Application No: FG/32/25/HH
Site Address: 1 Greenways Crescent Ferring BN12 5EF
Description of works: Erection of 1.8m high close boarded timber fencing along the eastern boundary.

Thank you for your internet representation made on 21st March 2025 which has been recorded as an objection with the comments as follows:

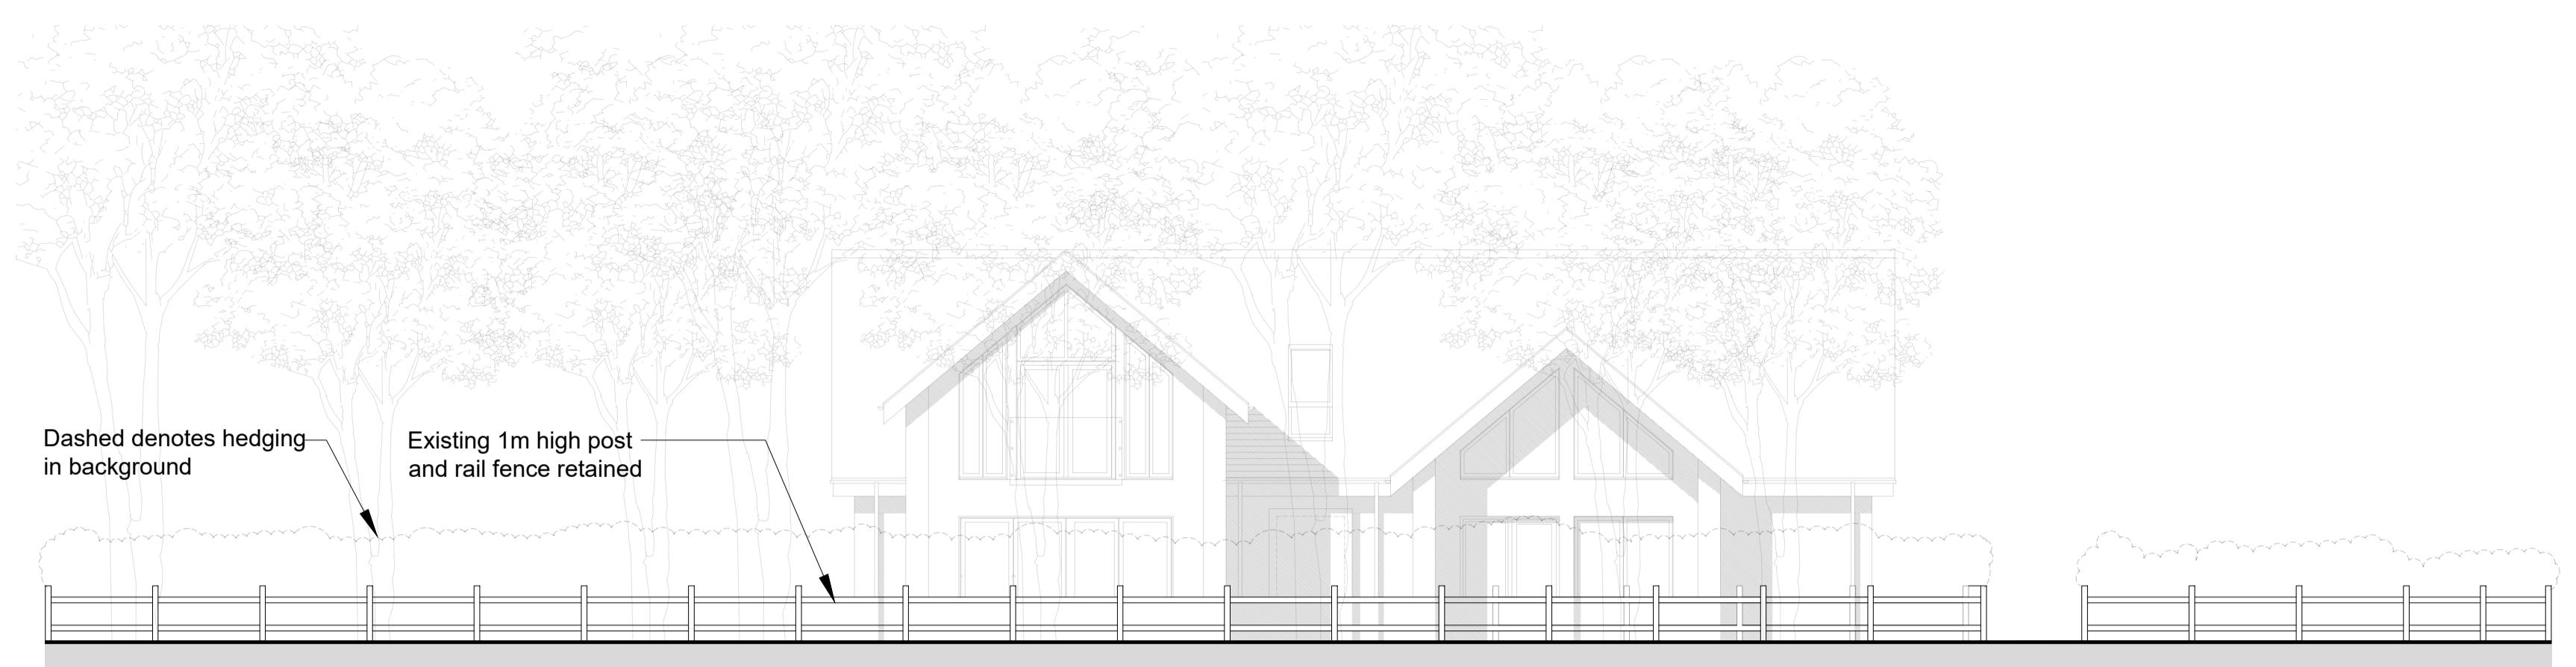
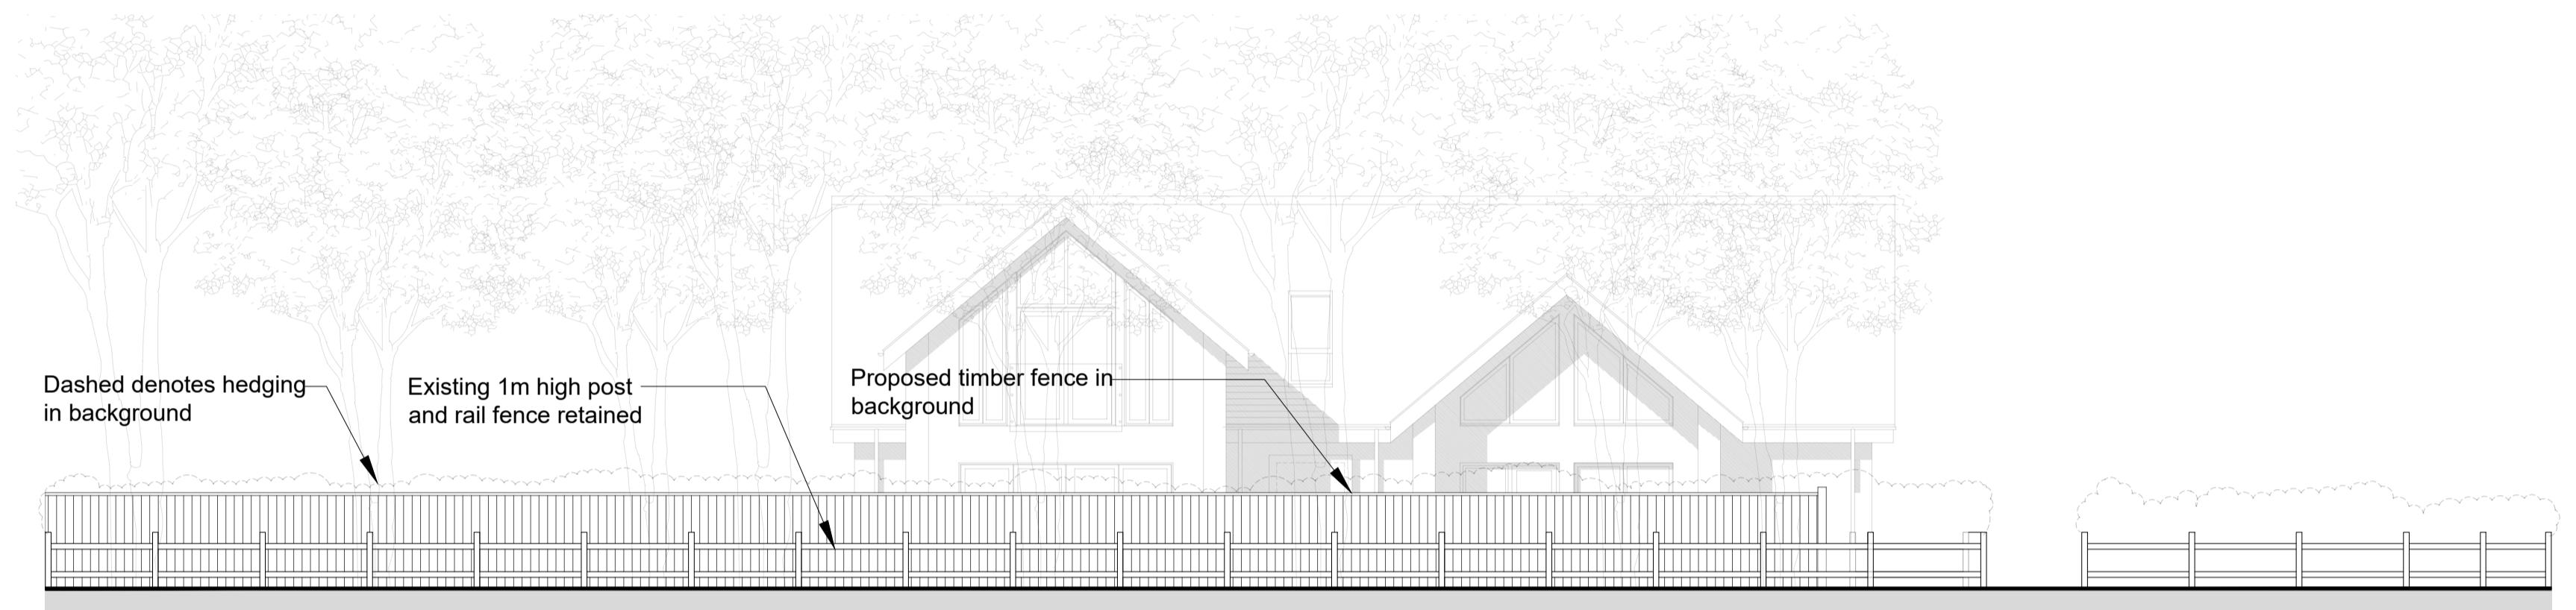
Ferring Conservation Group object to this application which will completely change the nature and character of the approach into Greenways Crescent. As the name suggests, it is predominantly a natural green setting of trees, open gardens and hedging. This application proposes to significantly impact that scene with long, high stockade style fencing, completely out of character for the setting.

Visually obtrusive, it will be at odds with section 5.13 of the Statement and Impact Assessment provided in the application FG/184/21/PL for the erection of a replacement dwelling and garage on the site. That statement and Impact Assessment placed considerable emphasis on the landscaping, planting, mitigation for damage to tree roots from post holes for the short section of fencing in that application and the inclusion of ground level gaps or holes (min. 100mm x 100mm) for the free movement of small mammals and to allow access for foraging on the site. These considerations have not been extended to this application.
